Recommendation Report for Planning Permission for Works or Extension to a Dwelling

REF NO: AB/44/21/HH

LOCATION: Fern Cottage
5A Surrey Street
Arundel
BN18 9DT

PROPOSAL: Proposed loft conversion (This application may affect the setting of the Arundel Conservation Area).

If the works:

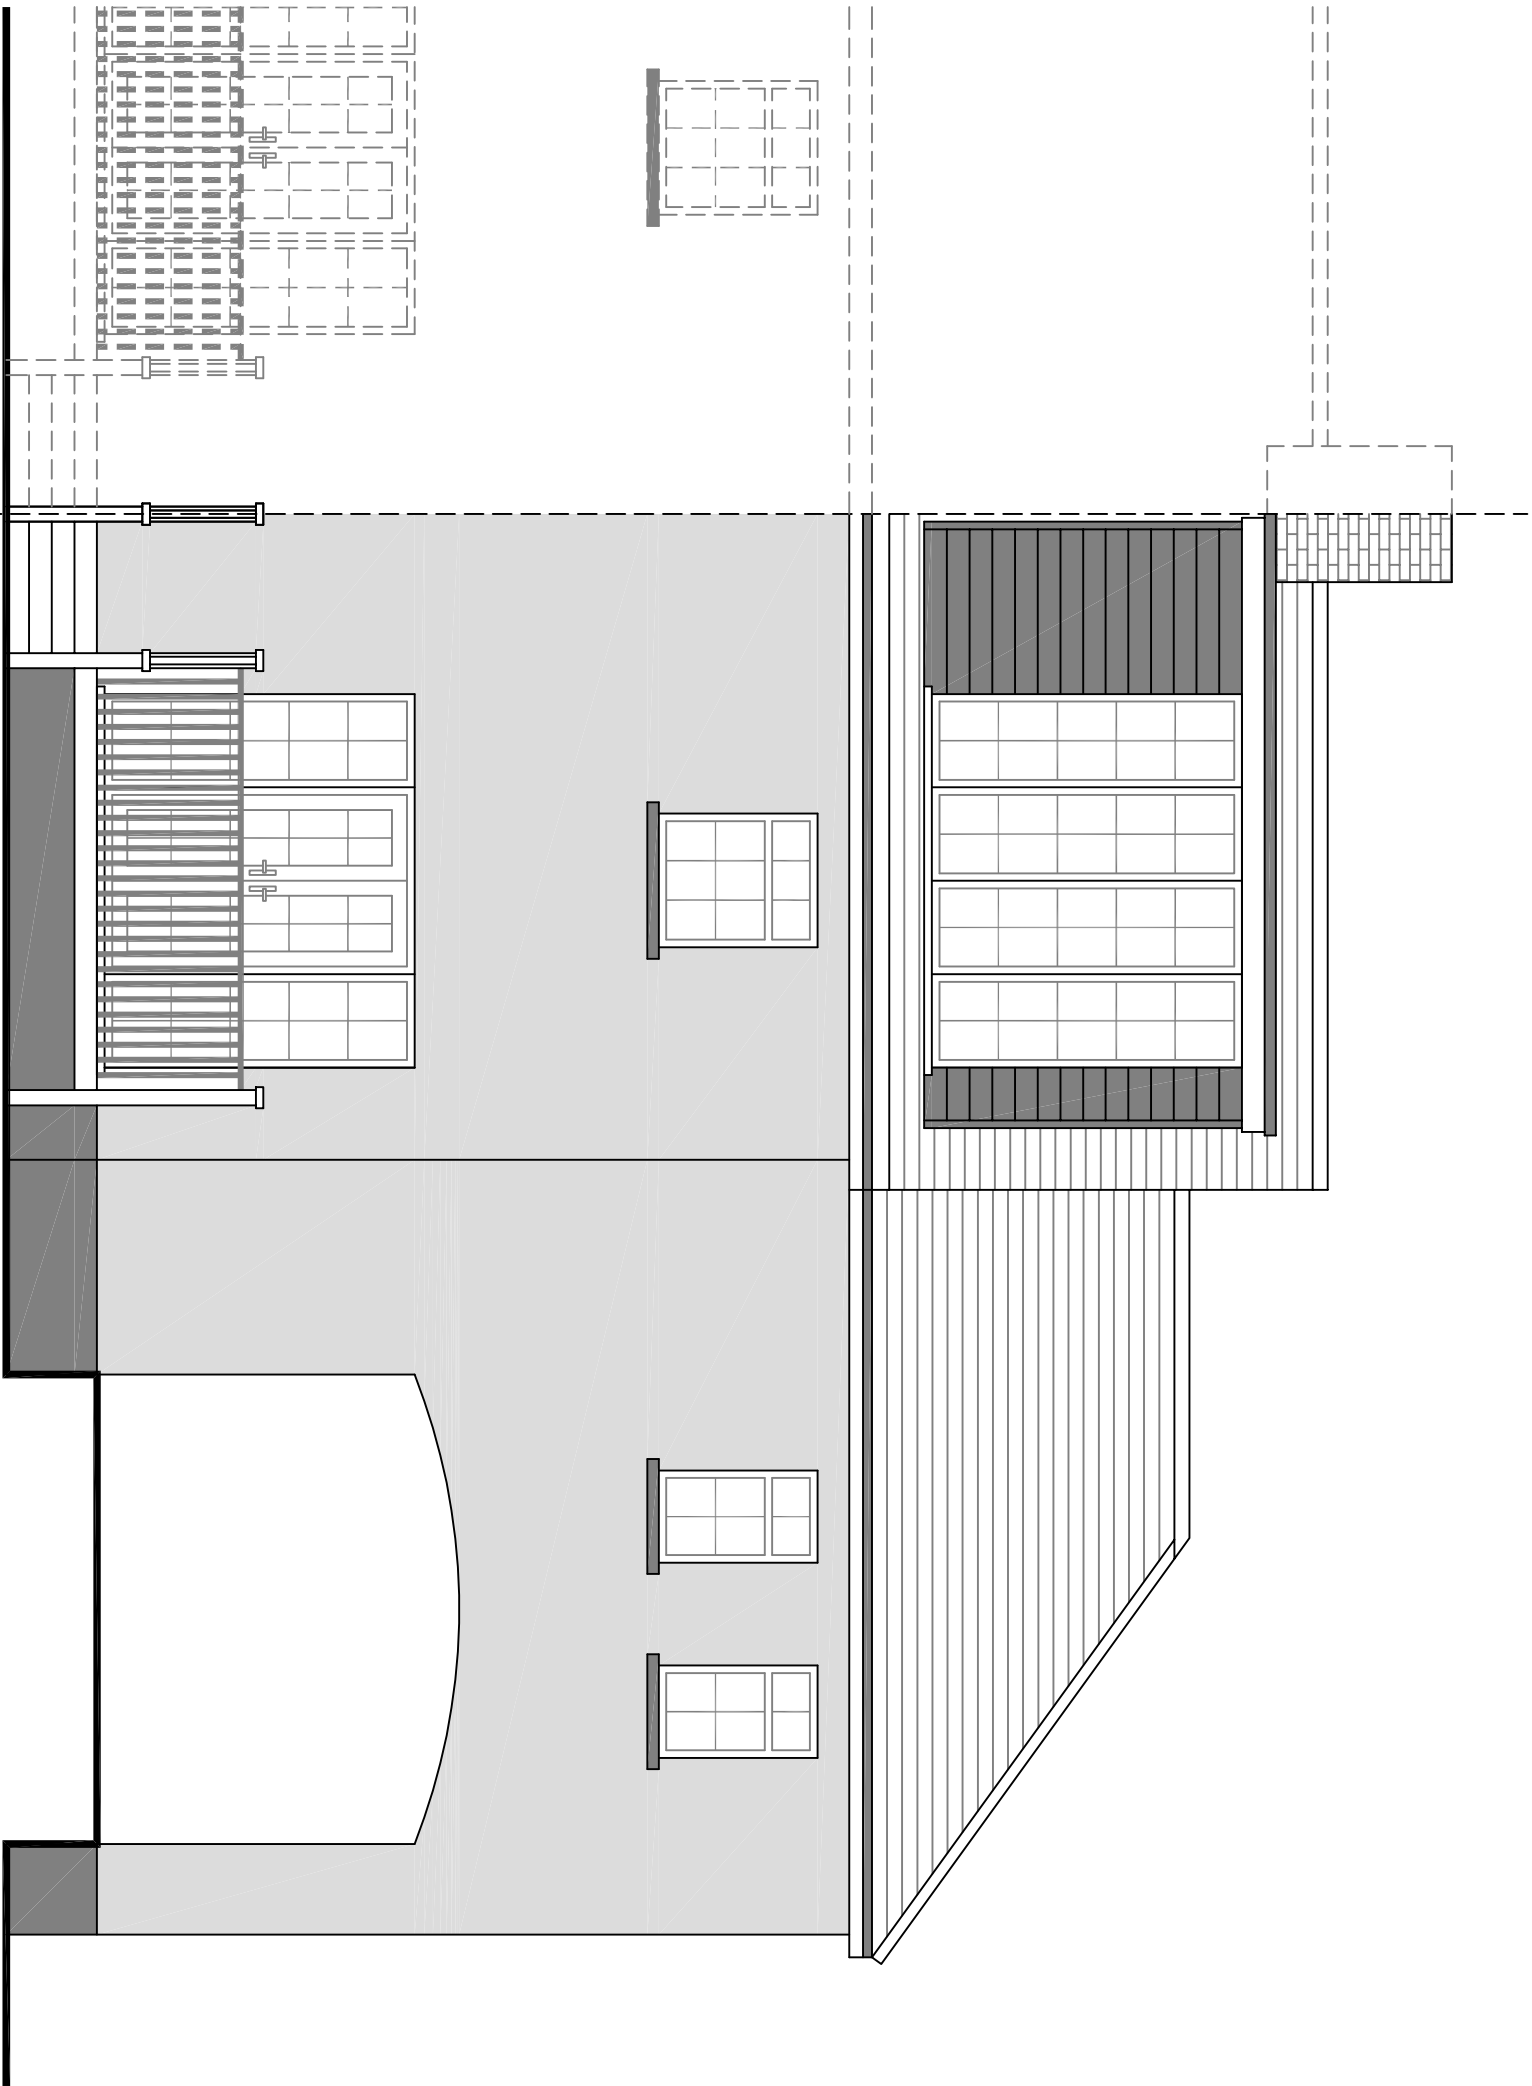
ADC Conservation Advisory Panel - Objection
-Change to roof shape will appear incongruent within street scene.
-Very large rooflights will detract from appearance of street scene and the setting of the listed buildings.
-Conflict with policy relating to protection of conservation area.
-Plans show inconsistencies with existing windows.
